**Case Officer:** Katherine Daniels

**Proposal:** Non-material amendment to 21/04158/F - 1. Reduction in height to the two flanks of the main hotel building by 654mm. 2. Reduction in height of the central lobby part of the hotel building by 990mm. 3. End facades pushed out on end/corner guestrooms by 52mm. 4. Six additional guestrooms (from 498 to 504) within the consented envelope of the building. 5. Extension to the flat roof of the waterpark support building (the "bunker") over the pitched section to form a dormer-like structure. 6. Updates to external window and door positions. 7. Removal of the Substation West (at the northern perimeter of the carpark) and minor alterations to the substations at the southern end of the car park within the landscape. 8. Additional doors on the flat roofs to facilitate safer means of emergency egress. 9. Rationalisation of window heights. 10. Addition of windows to the ballroom to improve natural daylight. 11. Relocation of access / maintenance entrances to provide more discreet, efficient and safer means of access. 12. Minor alterations to rainwater goods location setting out on the building to provide more efficient surface water collection.

Proposed Elevations - West

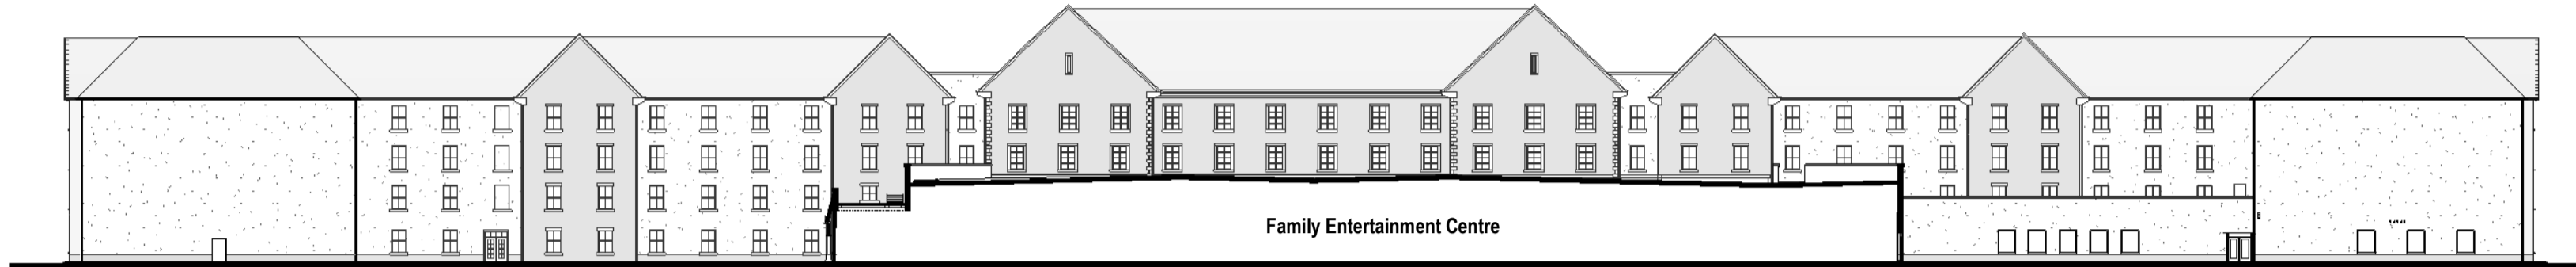
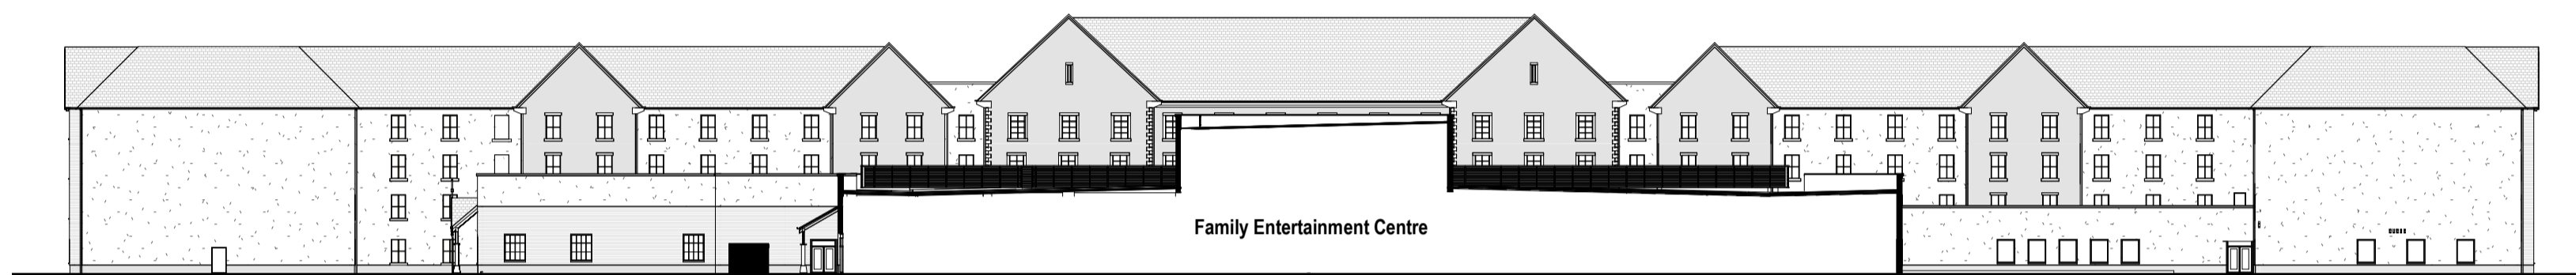
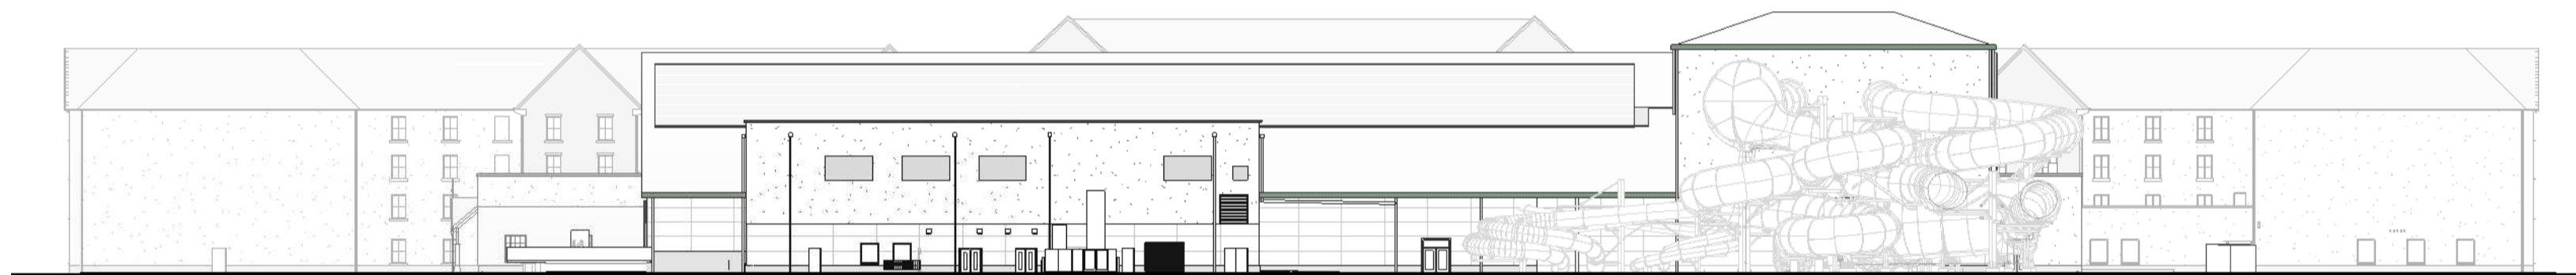
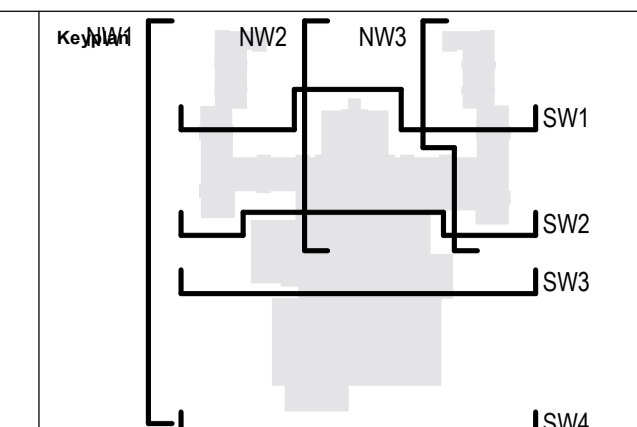
- 5.5. The proposal seeks to reduce the height of the two flanks and the central lobby. Although this reduction (at most) is 954mm, given the overall scale of the building, it is not a significant alteration. The appearance will still be the same. It is considered that this alteration is a non-material amendment.

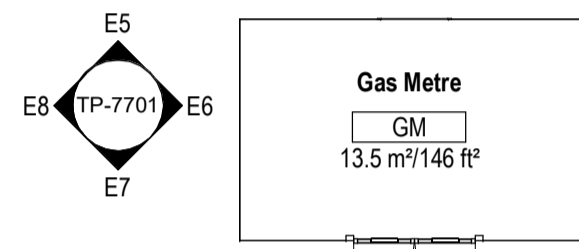
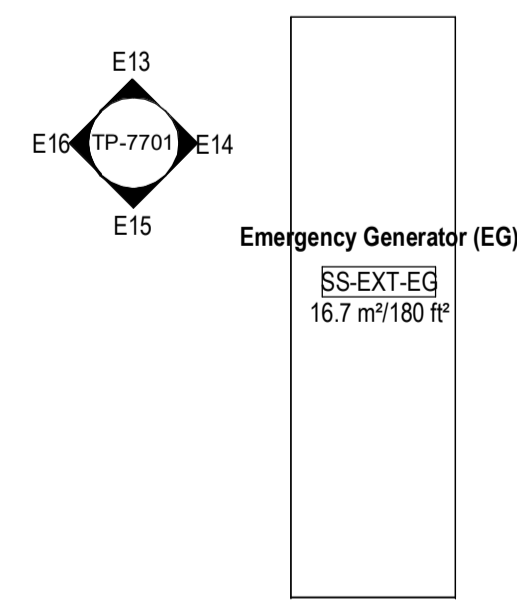
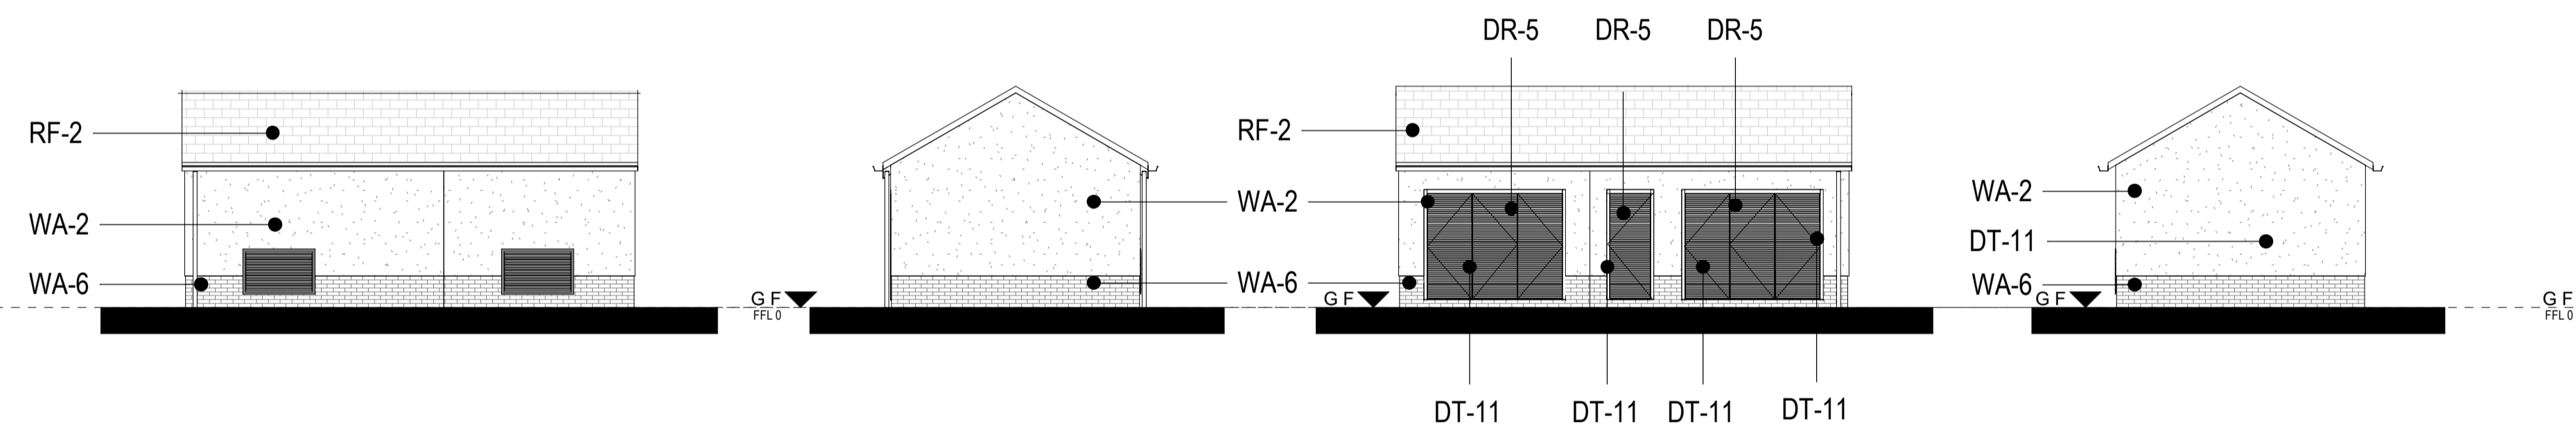
- 5.11. Following further design/build considerations, it has been determined that the scheme does not require two substations. As a result, one has been omitted from the scheme. Overall, the built form has been reduced, and would result in an insignificant alteration to the overall scheme.
